DRB Application No : 08DRB-70034 Project # 1003812
 Project Name. Village De Las Mananitas
 Agent: Consensus Planning Phone No 764-9801

DEVELOPMENT REVIEW BOARD – SPEED MEMO

DRB CASE NO: 1003812/1004240

Date: March 11, 2009
To: Jack Cloud, DRB Chair
From: Carol Toffaleti, Staff Planner, Development Review, 924-3345
Subject: Project #1003812 – Las Mañanitas
08EPC-40118 Site Development Plan for Building Permit

**VILLAGE AT LAS MAÑANITAS
 CONCEPTUAL UTILITY PLAN**

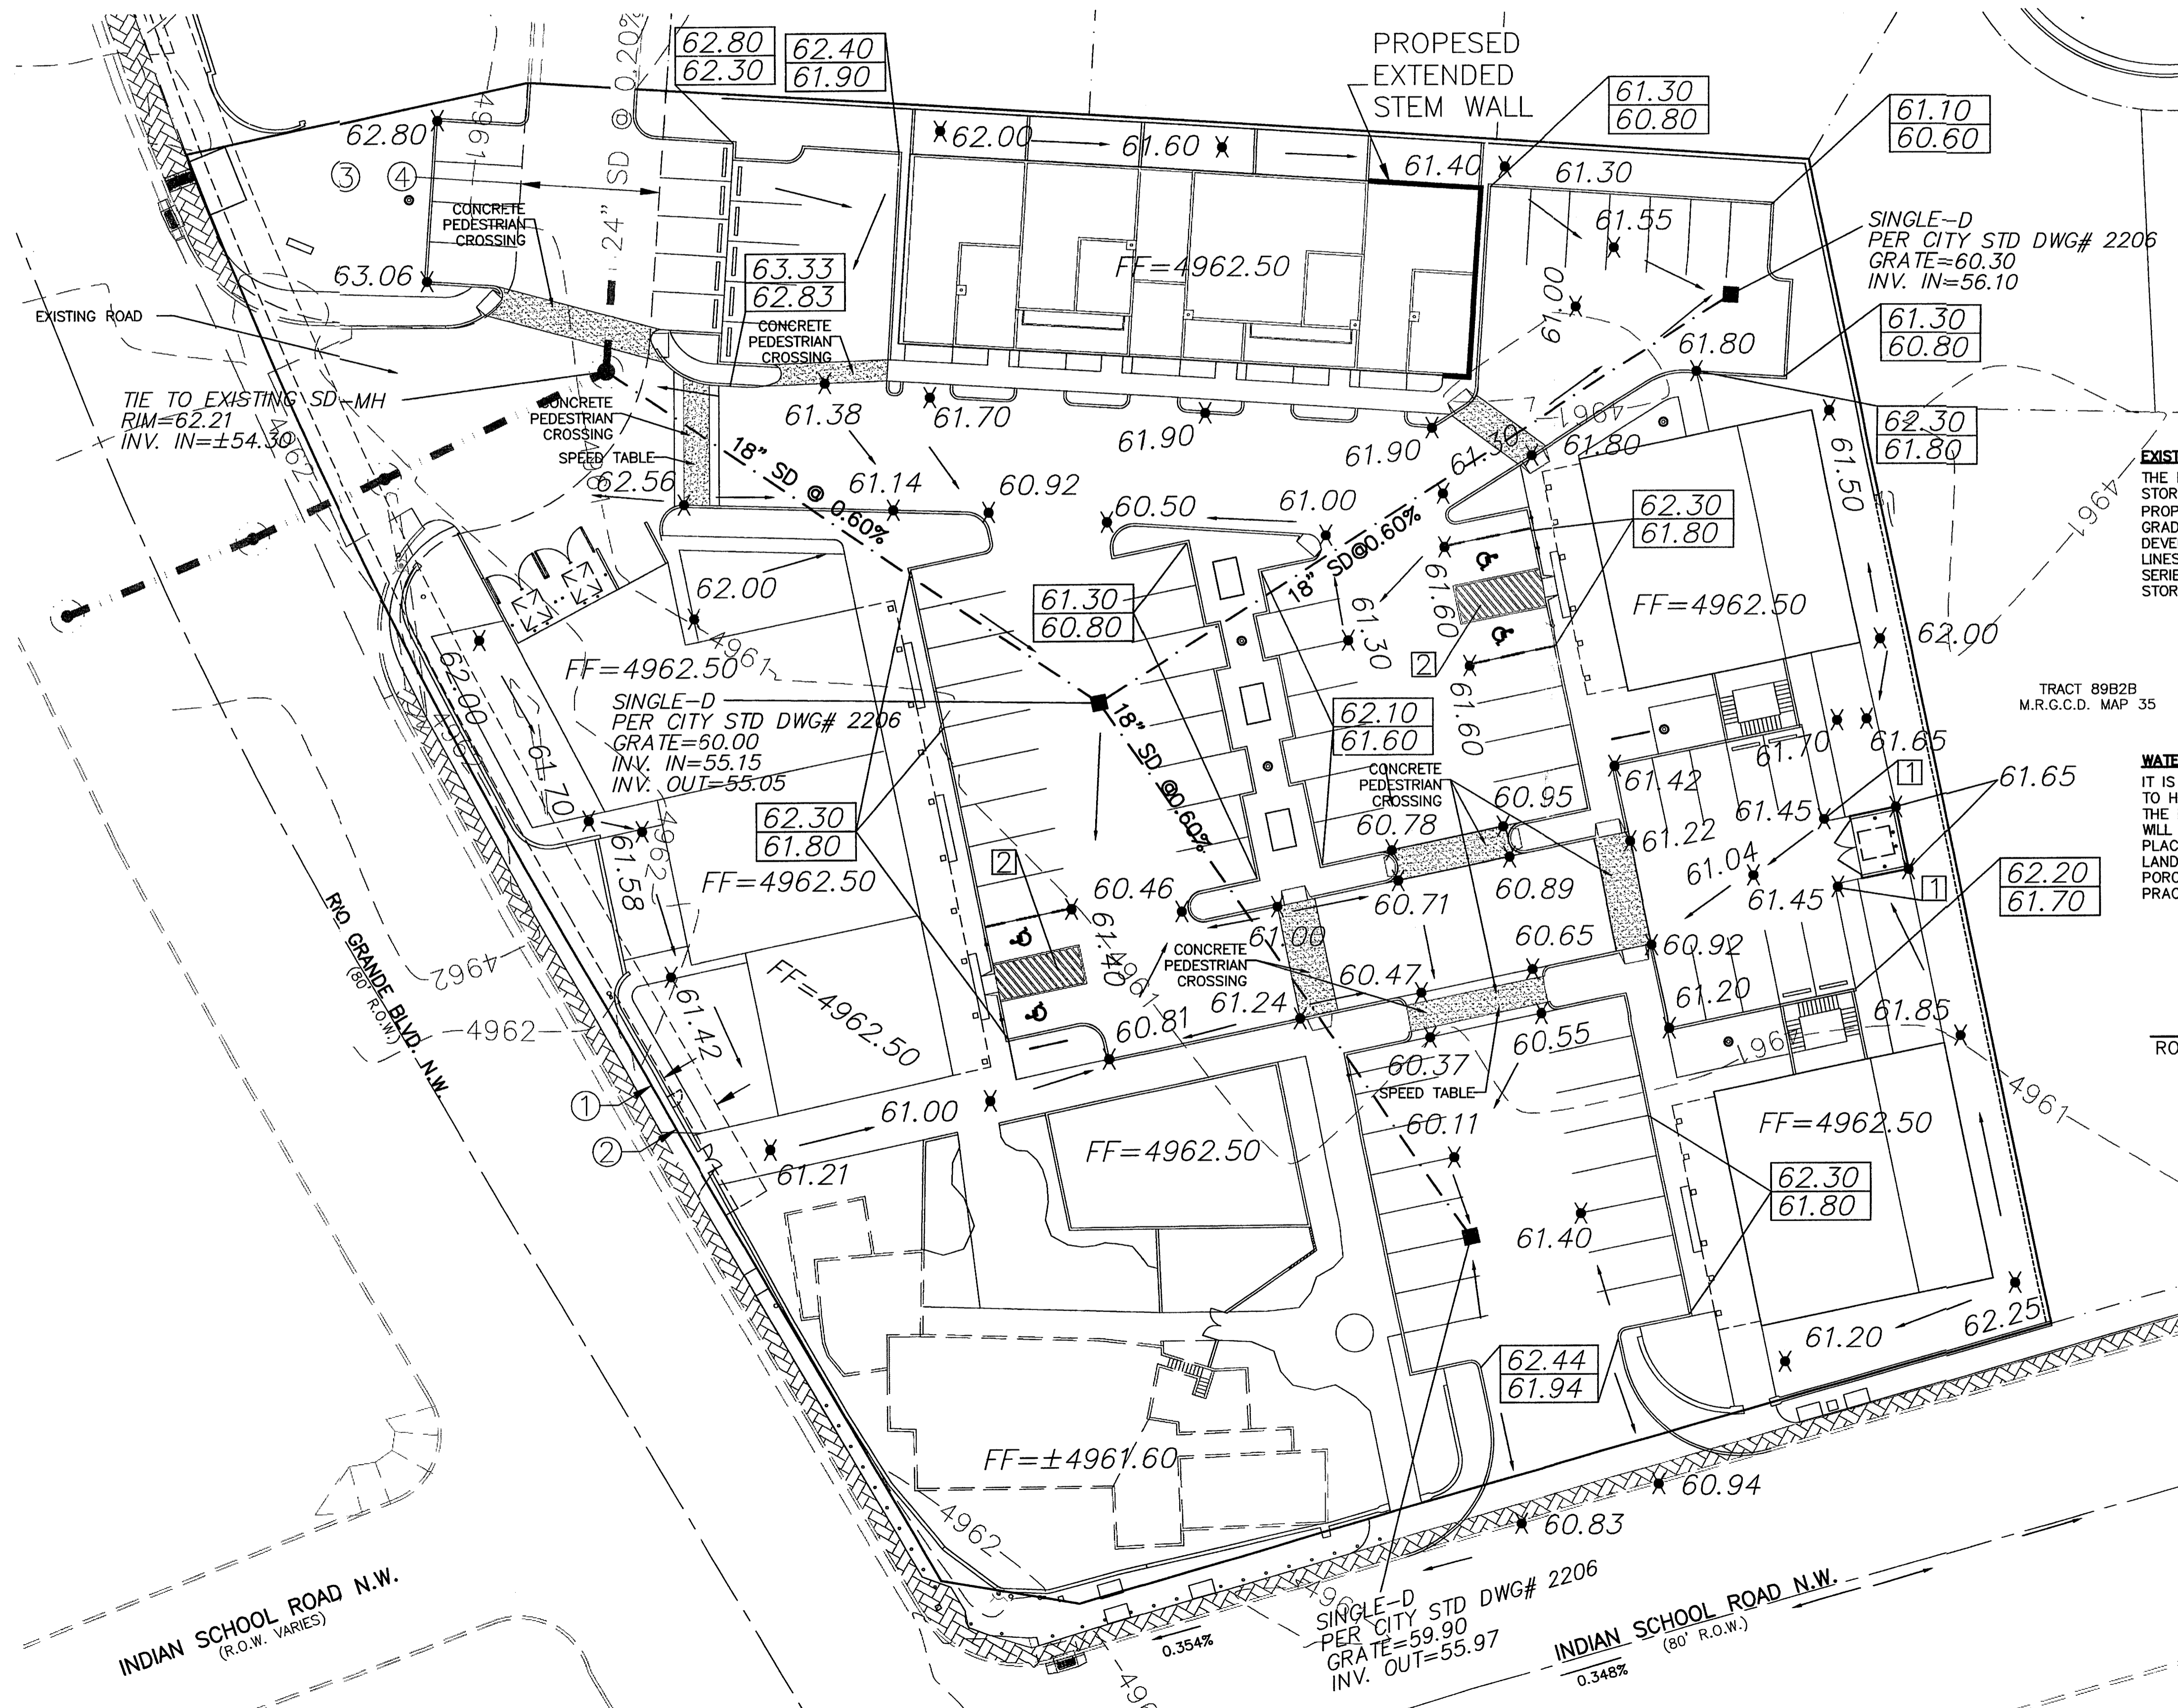
Condition 17: The label for Building E on the utility plan must be changed to “live/work units”.

EAST ELEVATION / BUILDING 'C'
EAST ELEVATION / BUILDING 'D' (Opposite Hand)
1/8" = 1'-0"

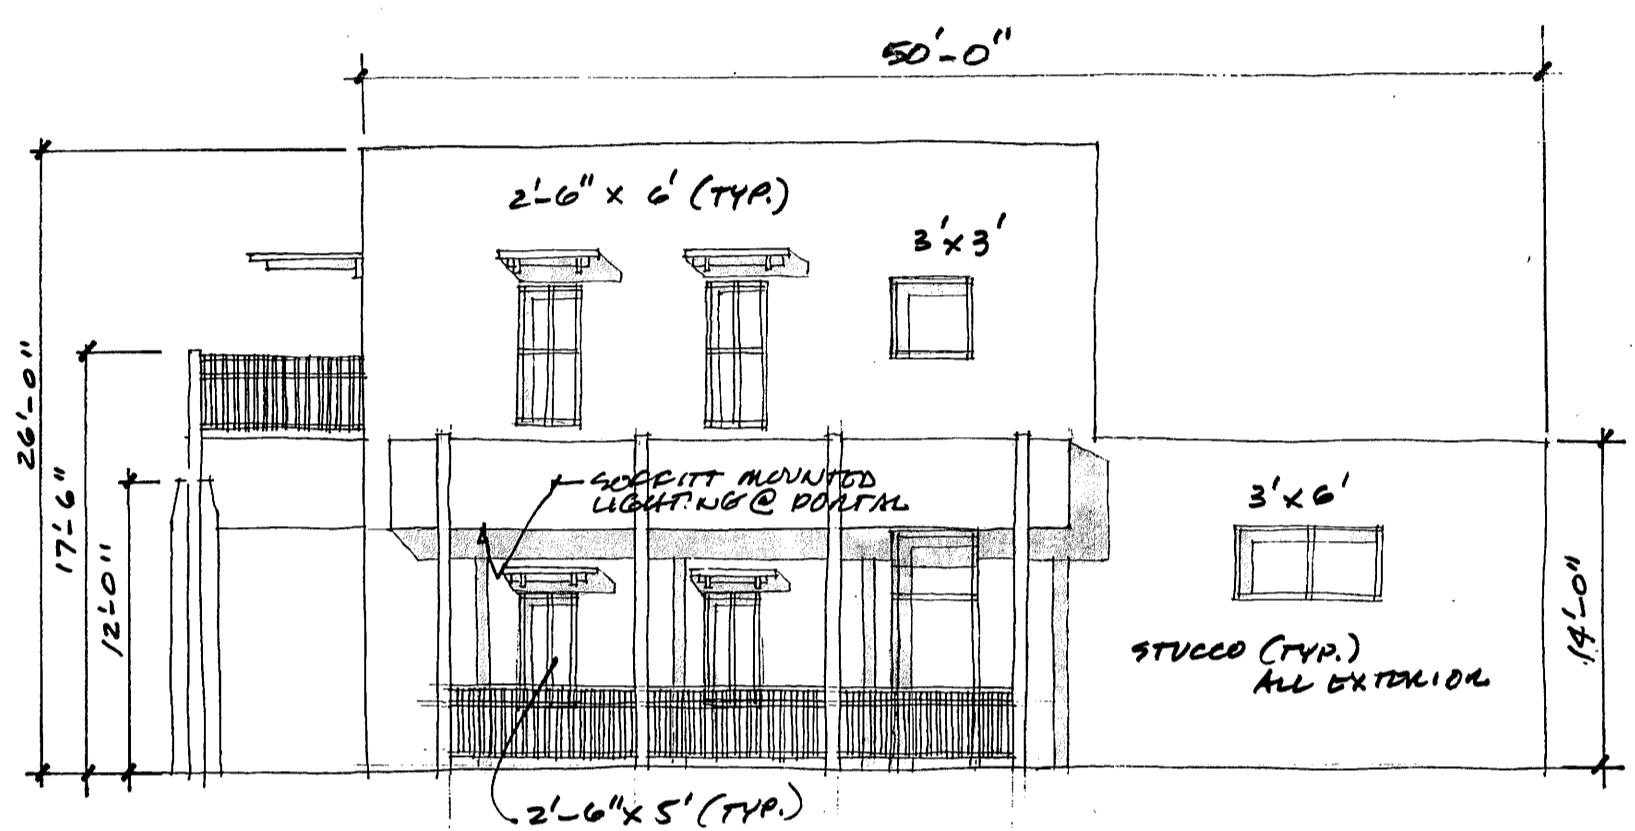
On sheet SDP-5, it is the *East* elevation of Building D that appears to include a portal.

Please add a note like the one added to West Elevation Bldg C.

- The recycle enclosure and gate must be added to detail A2 on sheet SDP-1 and to the north elevation of Blvd. F on sheet SDP-6.
- On sheet SDP-5, clarify that the portal shown on the east elevation of the buildings only applies to Bldg C.

WEST ELEVATION BUILDING 'C'
1/8" = 1'-0"

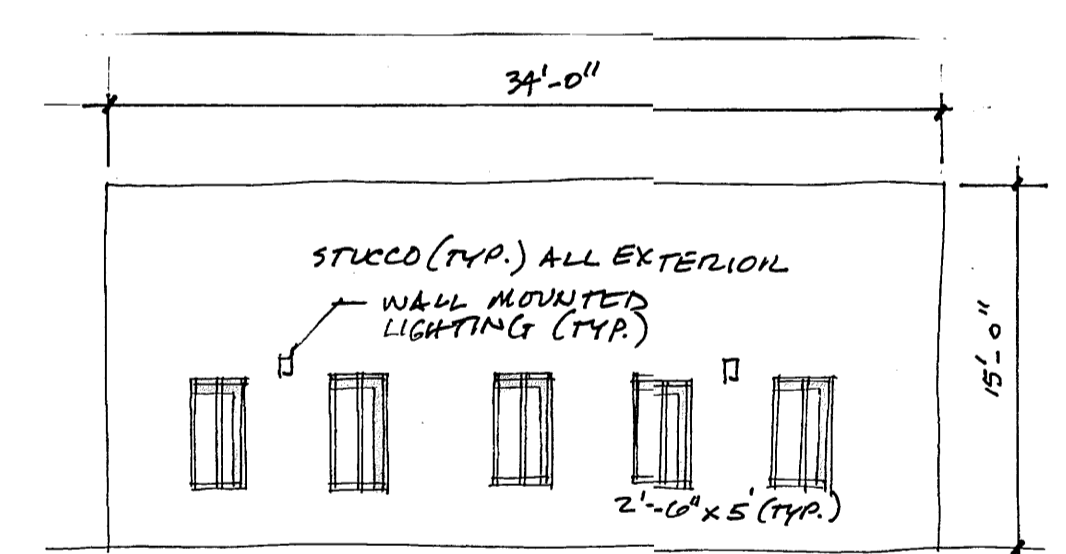
Condition 13.a. Architecture: On the west elevation of Bldg C, the distance between the tower and the building is labeled as 6 ft, but scales at 4.5 ft. This should be corrected. The distance on Bldg D also scales at 4.5 ft. Staff defers to the City Engineer to determine whether this provides an acceptable path for pedestrians in these areas.
